DEVELOPMENT HEARING OFFICER (DHO)

PR-2023-008674
SD-2024-00163 – FINAL PLAT

REQUEST: Final Plat for Playa Del Sur

**8'-0" CMU CMU GARDEN WALL**

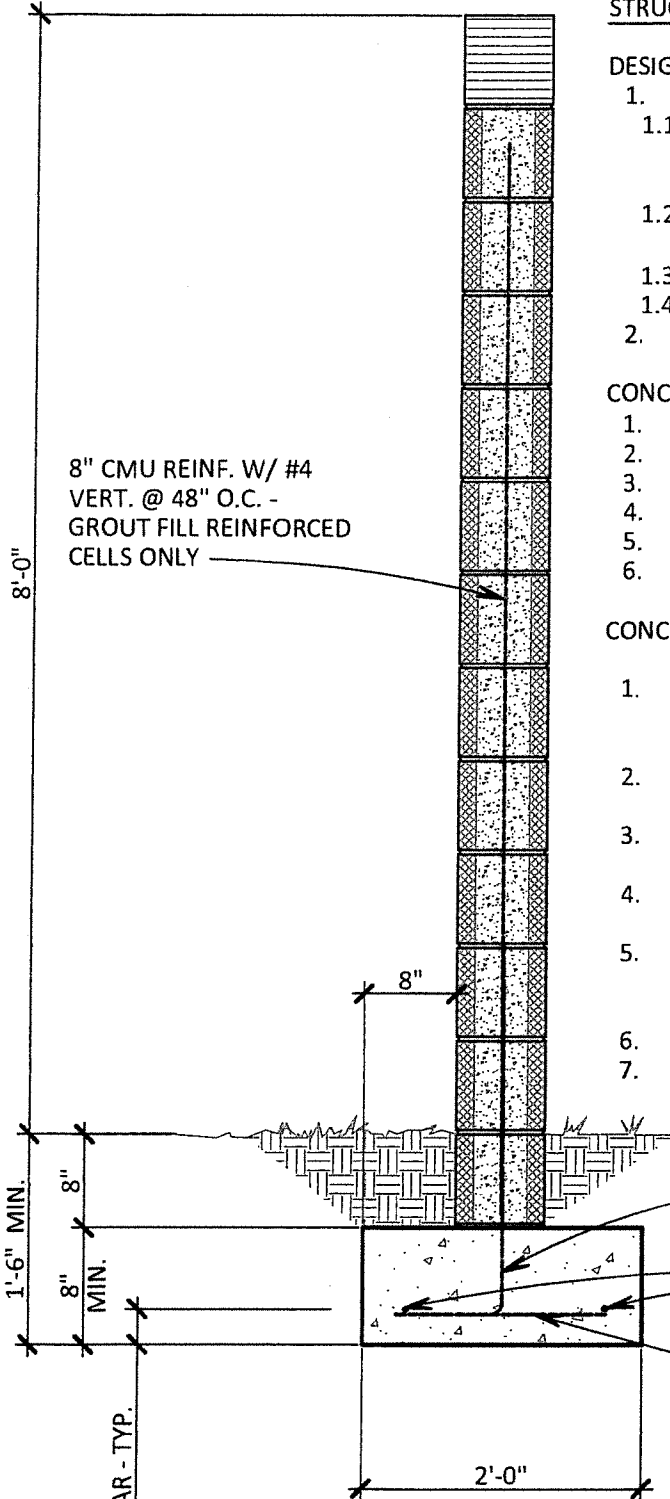
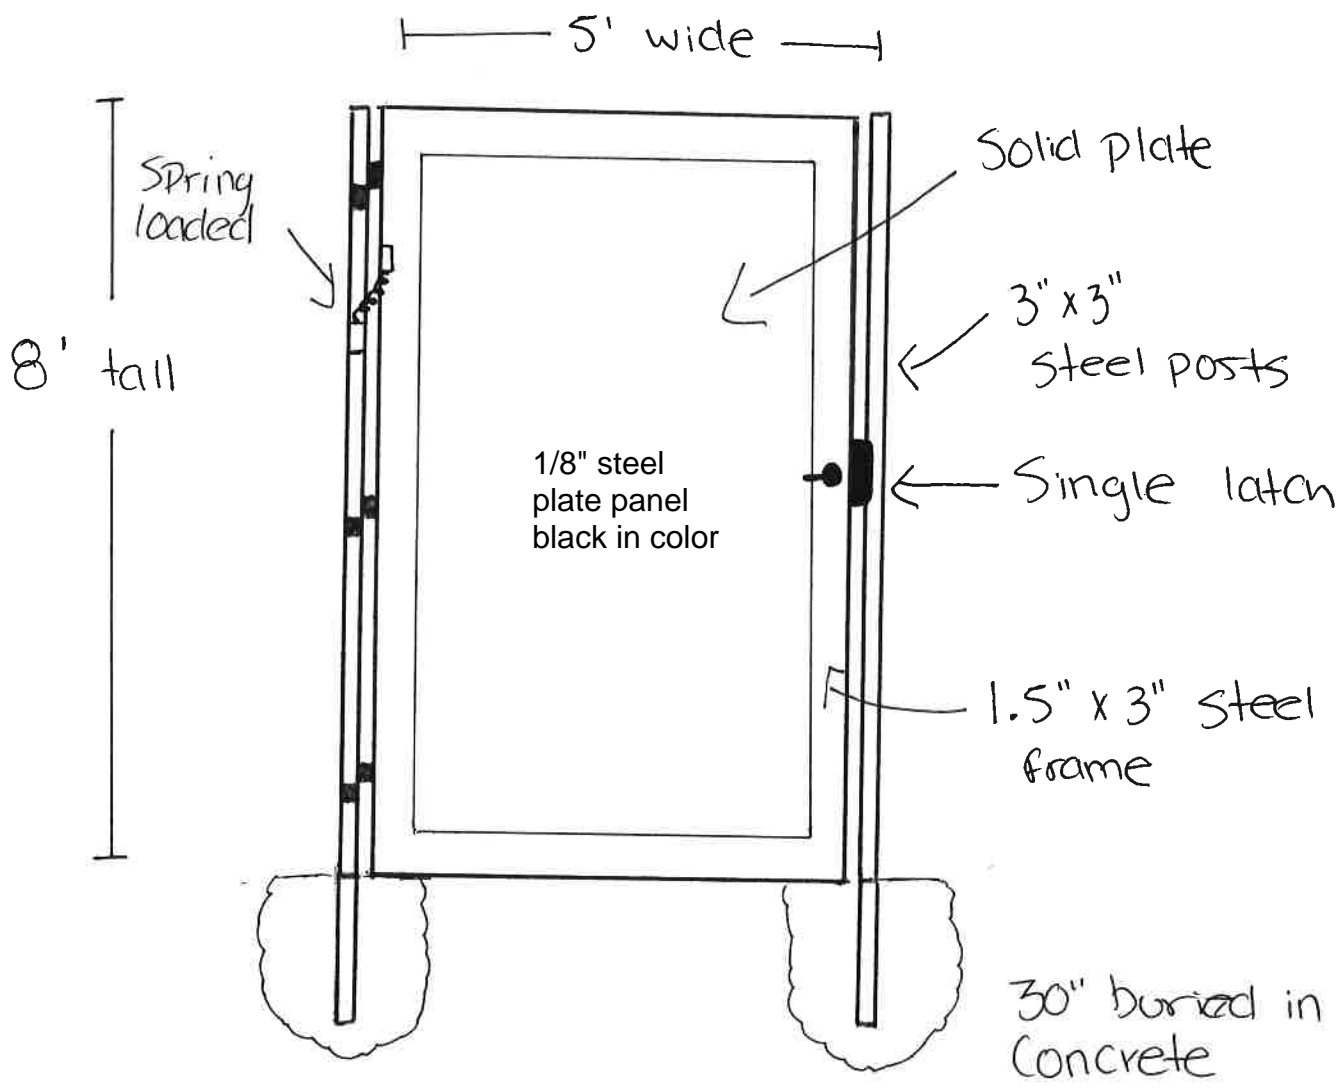
The proposed wall adjacent to the existing paved trail must comply with the following requirements from the DPM and IDO:

1. Exposed flat-faced CMU blocks shall not constitute more than 50 percent of any wall facing a public street or City Park or trail.

Portions of walls that obtain approval for a wall that exceeds the maximum height limits in Subsection 14-16-5-7(D) (Maximum Wall Height) or are required to exceed those limits and that face any public street, City Park or trail, Major Public Open Space, or major arroyo, shall incorporate at least 1 of the following features to break up the massing of the wall. (See figure below for illustrations of each option).

Any portions of a wall over 3 feet facing a public street, City Park or trail, Major Public Open Space, or major arroyo shall comply with at least 1 of the following options. (See figure below for illustrations of each option).
